From: Sue Howell
Sent: 21 April 2015 17:11
To: Planning.Responses
Cc: Neil Crowther
Subject: RE: Planning Consultation on: A/23/15/OUT

APPLICATION **A/23/15/OUT**

Site Address: Land south of New Road (A259) and East of
 Brook Lane Angmering N/A

Description of Works: Hybrid application - Full Planning Permission for a retail unit (Class A1) comprising 1,487sqm (1022sqm ground floor and 465sqm mezzanine) with associated access, car parking, servicing, landscaping & associated works.
 Outline Planning Permission for a public house (Class A4) comprising 581sqm at ground floor level.

| Drawing Number<br>1117-P-11 | Revision<br>E    |

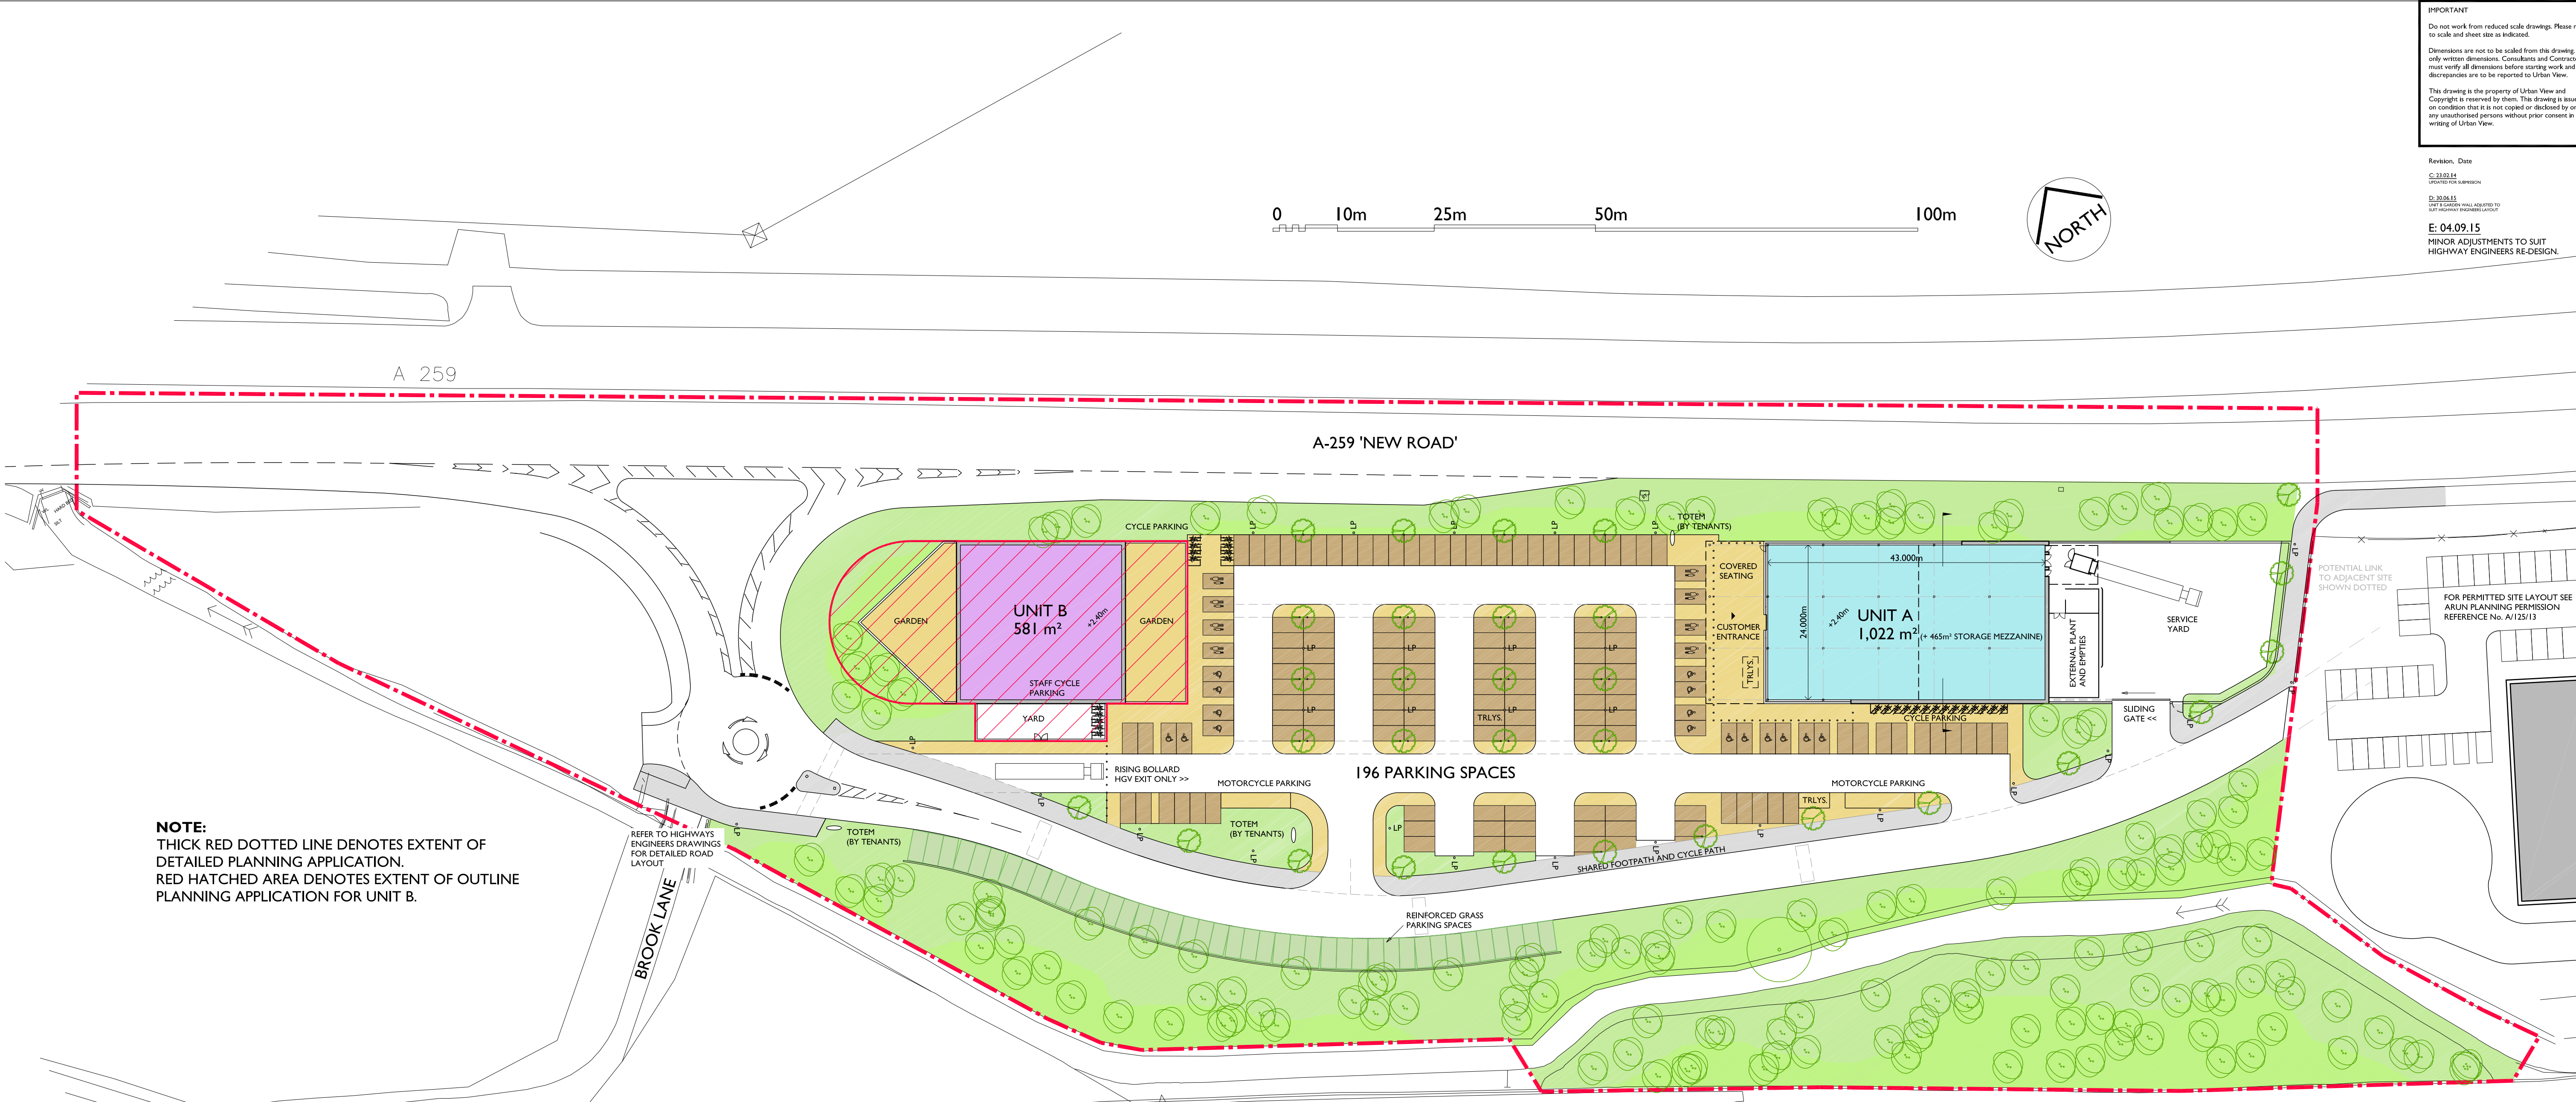
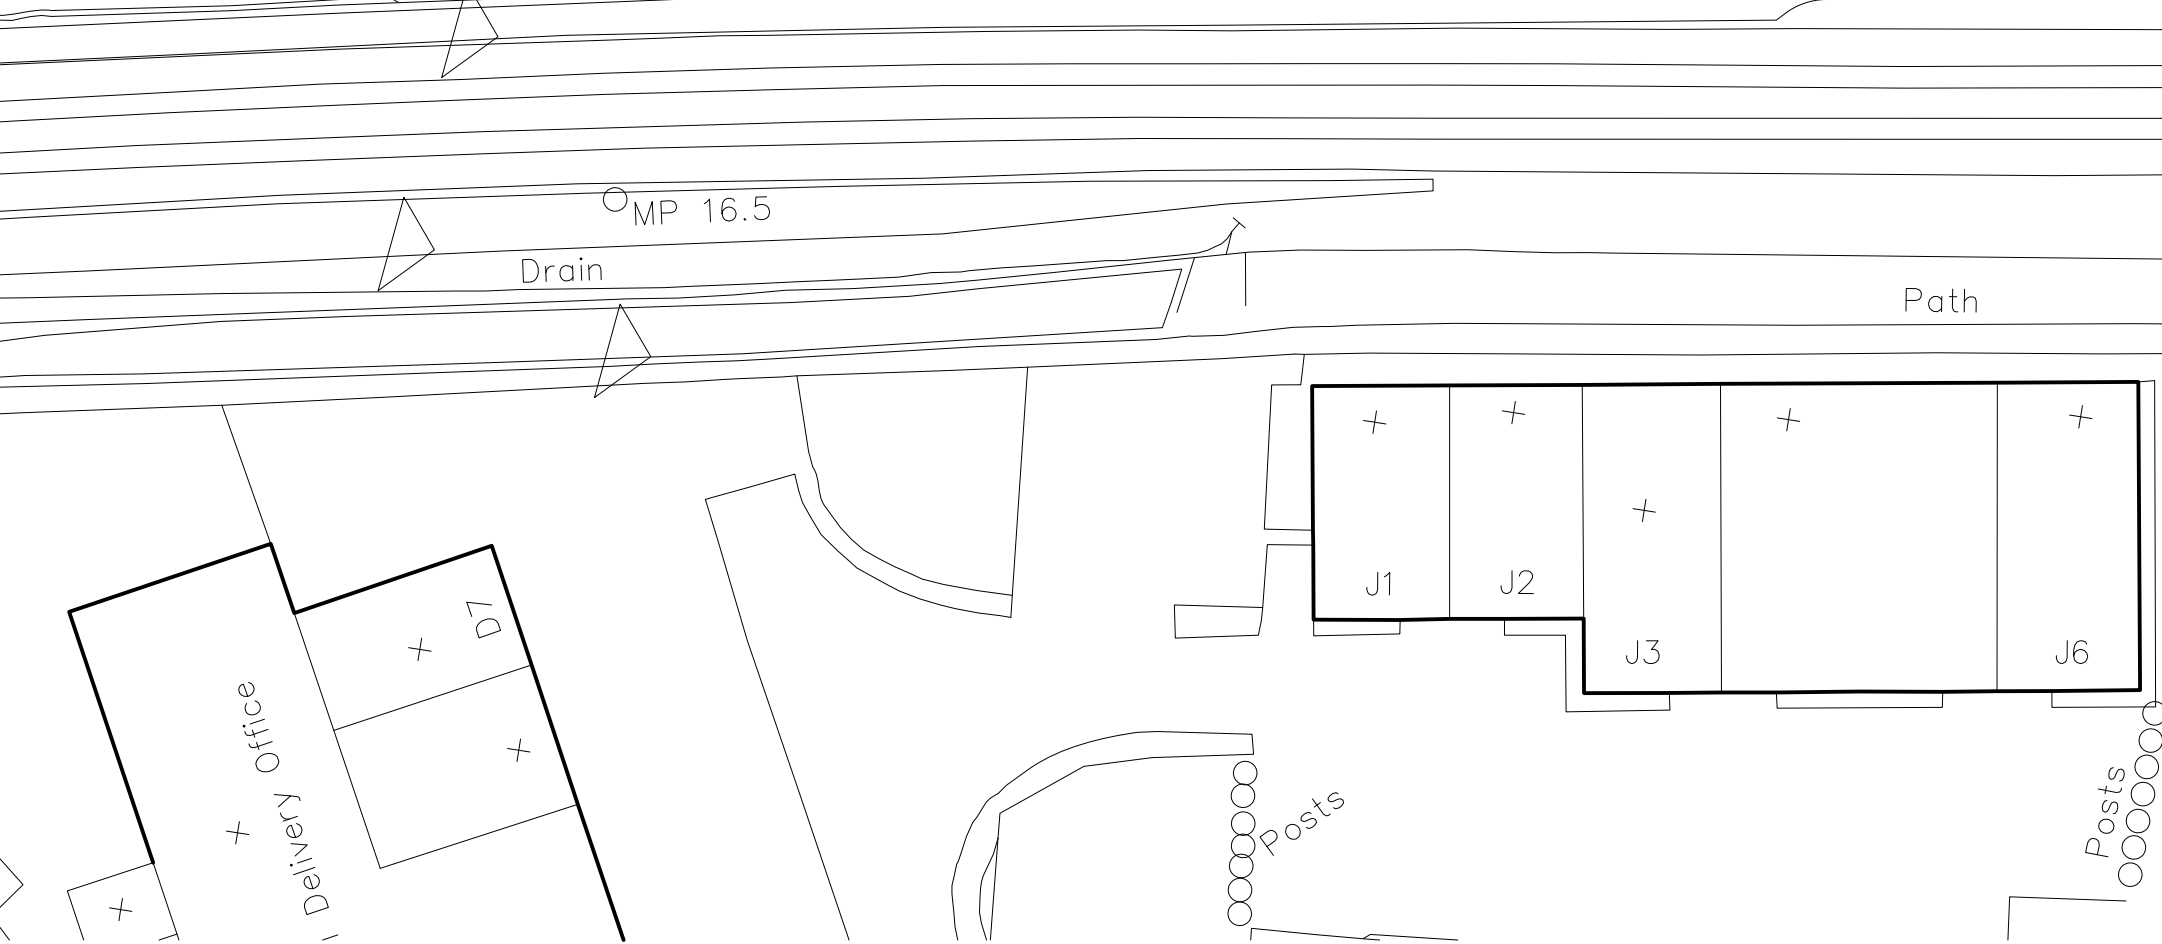
Landscape drawings 1117-P-11 Rev C and KL.264.001 Rev C show indicative schemes, which whilst show a comprehensive mix are only an indicative layout. Plans would be required that detail a full landscape scheme submitted for approval. These would need to detail species choice, position, densities and size at time of planting. These should be plotted in plan and list form and in relation to the trees and vegetation to be retained so that a clear picture of the proposals can be seen. These details are required to ensure that appropriate screening is provided, maintaining and uncompromising the setting and ensuring that the proposals fit within the area of neighbouring development and properties and neighbouring South Downs National Park, whilst benefiting the potential of the proposed developments usage.
